Submission RE 38-42 Anderson St and 3 McIntosh St and 2 Day St (SSD-74670720)

Executive summary

This submission deals with traffic/active transport issues connected with the subject site. It is contended that:

FIGURE 5
WILLOUGHBY COUNCIL BICYCLE NETWORK SURROUNDING THE SUBJECT SITE

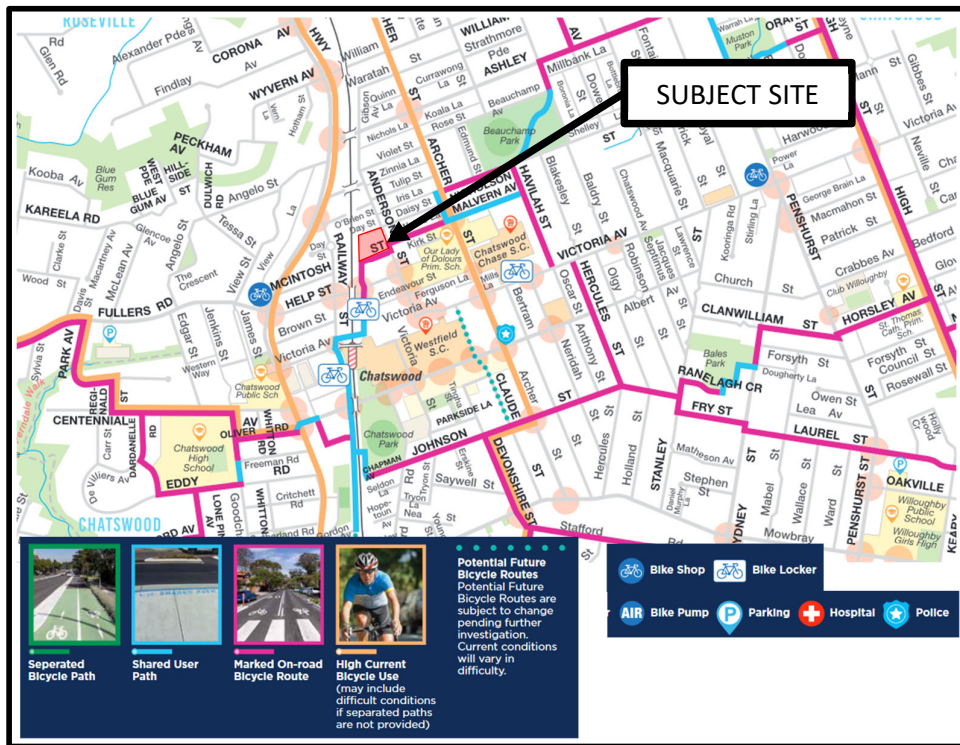
The bike route map (TIA Fig 4) appears to be the North Shore Bike Map, not the Willoughby Bike Map (no map of that name is known), as is indicated in the TIA

The provided map (TIA Fig 4) indicates an on road/shared path bike route to the station along Orchard Rd. The writer is not aware of any local on road or wayfinding signage that supports that bike route/shared path characterisation (Fig 1).

From the above, it appears that a bike route from the proposed development site to the station remains to be completed, contrary to the proponent's map.
